Application for a non-material amendment following a grant of planning permission.

Address 3: FORZEDOWN

Town: LITTLEHAMPTON

Replacement of existing windows with new PUCu double glazed windows

Drg. No.: CC2592-01

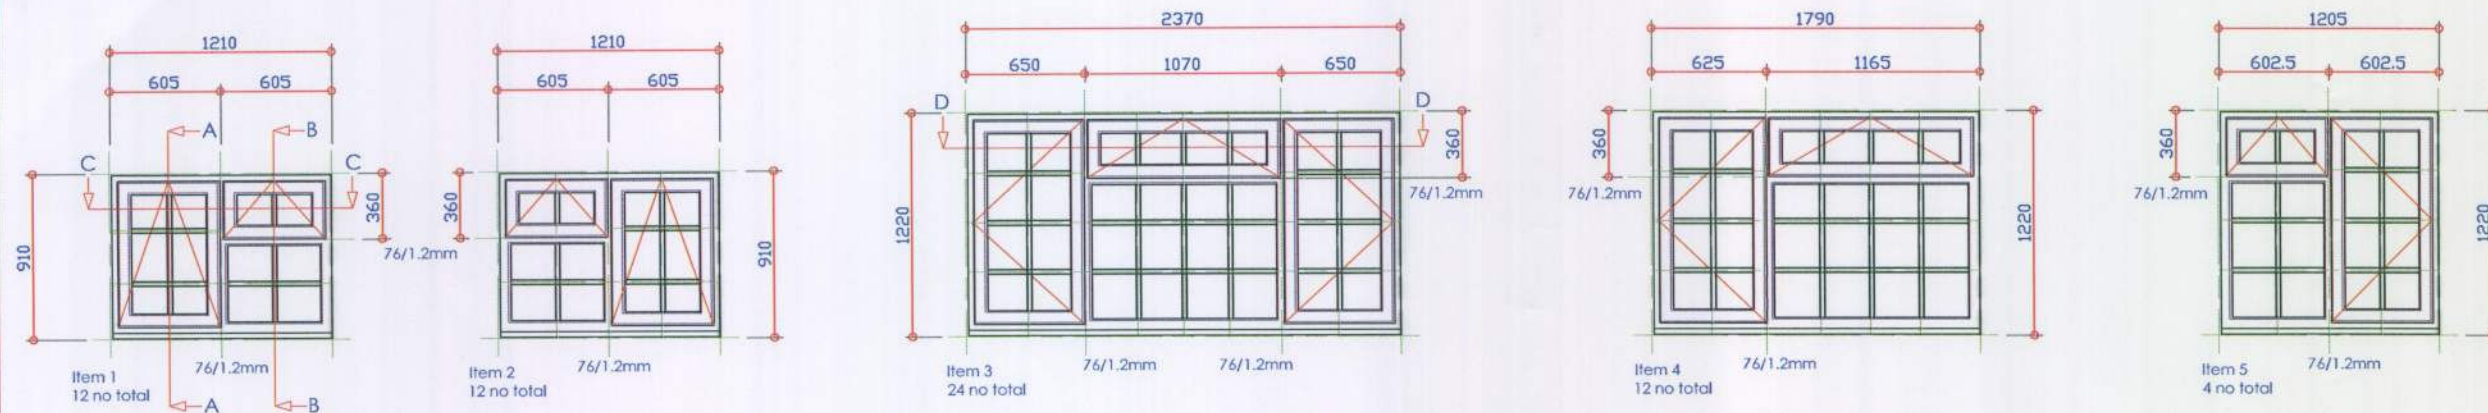
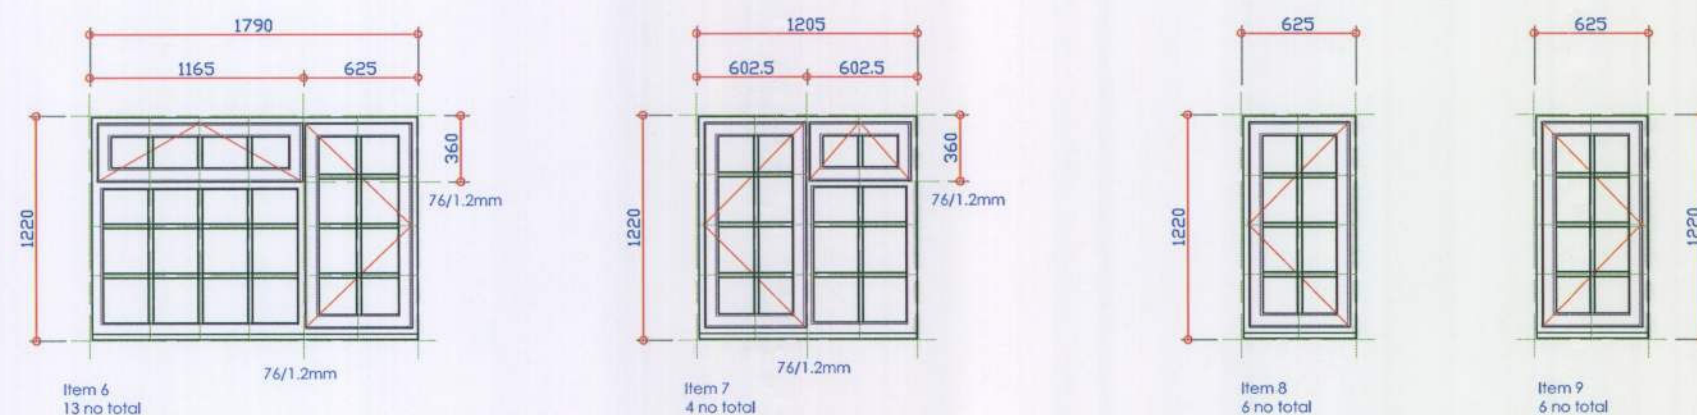
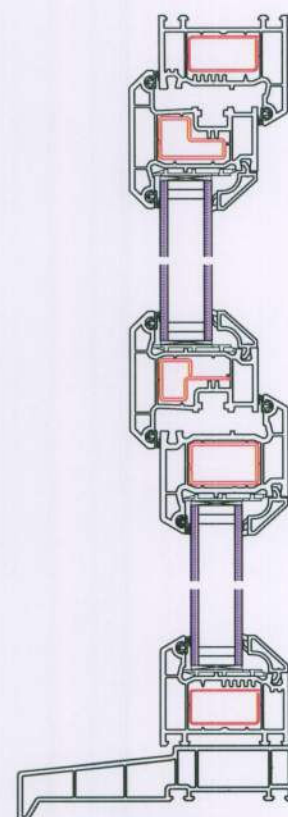
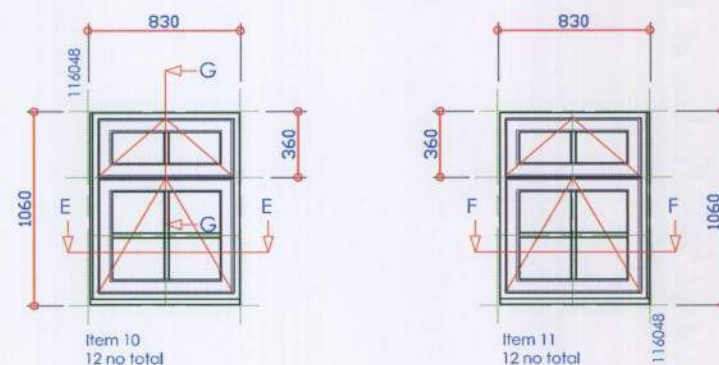
Revisions to window fenestrations, - reduction in size of opening casements to Items 3, 4, 6 on attached drawing CC 2592-01 Rev C
Glazing bars added to window drawings to match existing window styles (georgian bar).

Original side hung casements to large and outside of manufacturers tolerances.
Glazing bars added to drawings to match existing window styles.
